Subject: PO/16/21/DOC

Peckhams Poling Street Poling BN18 9PT

Approval of details reserved by condition imposed under ref PO/8/21/L relating to Condition No 2 - details of wood treatment and new windows and doors

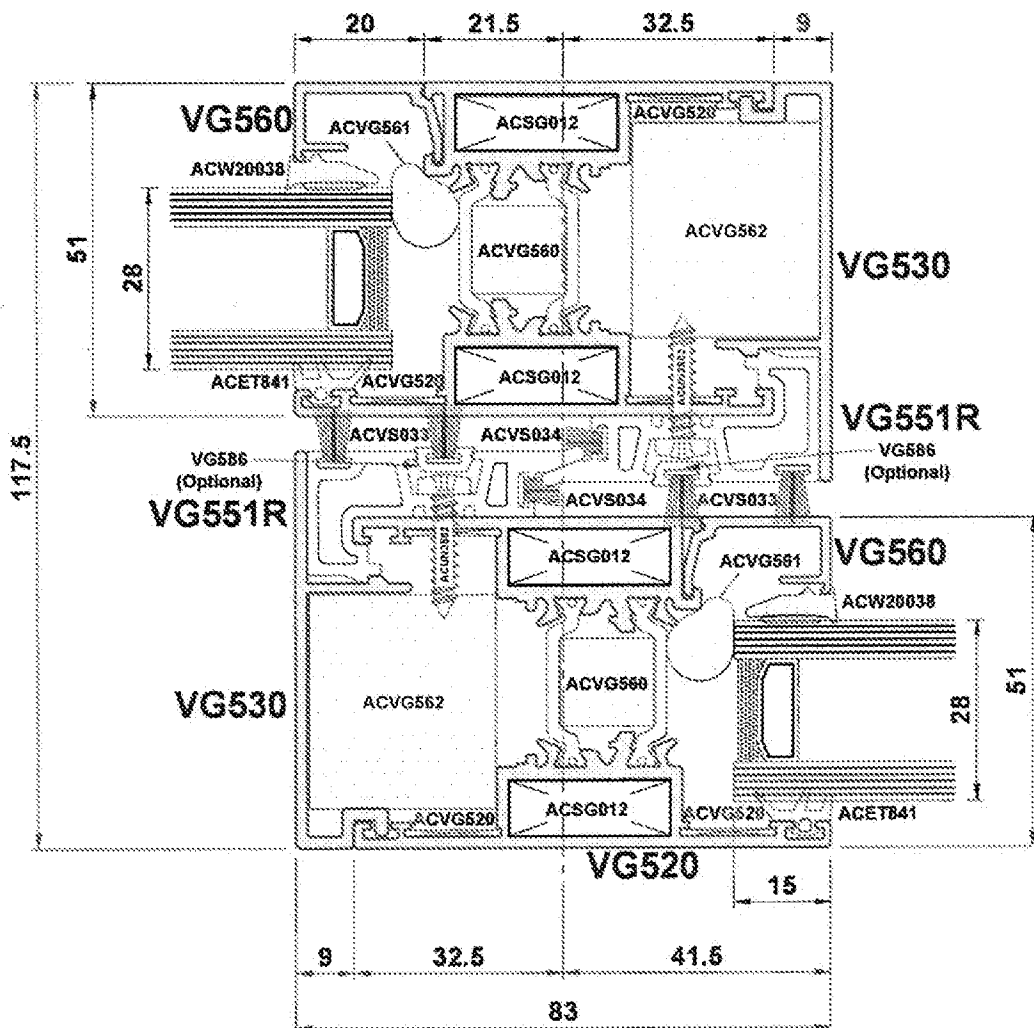
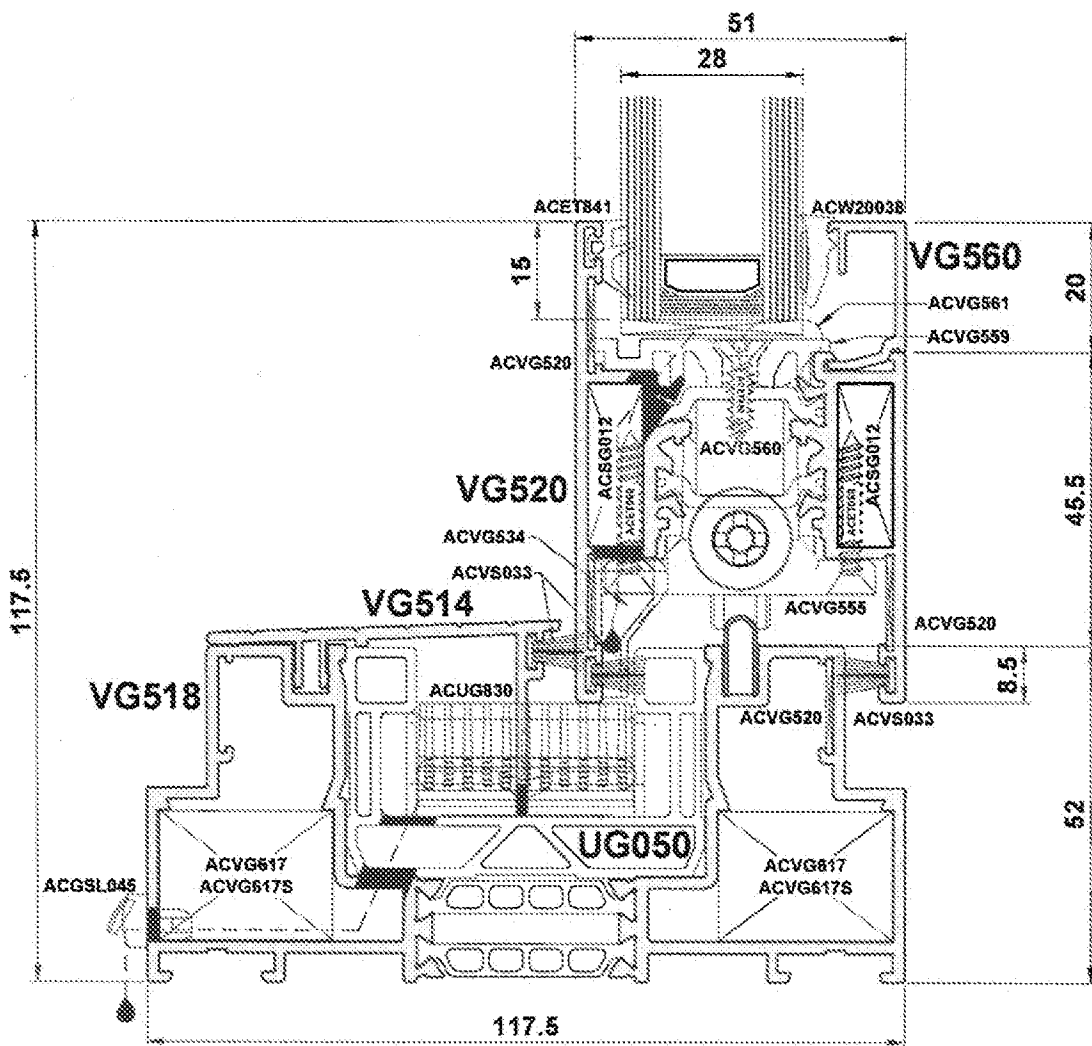
The proposed rooflights seem to be acceptable. However, the level of information regarding the windows is limited to two photographs. It would help to have sections of the sliding doors – which were not clearly displayed on the approved consent.
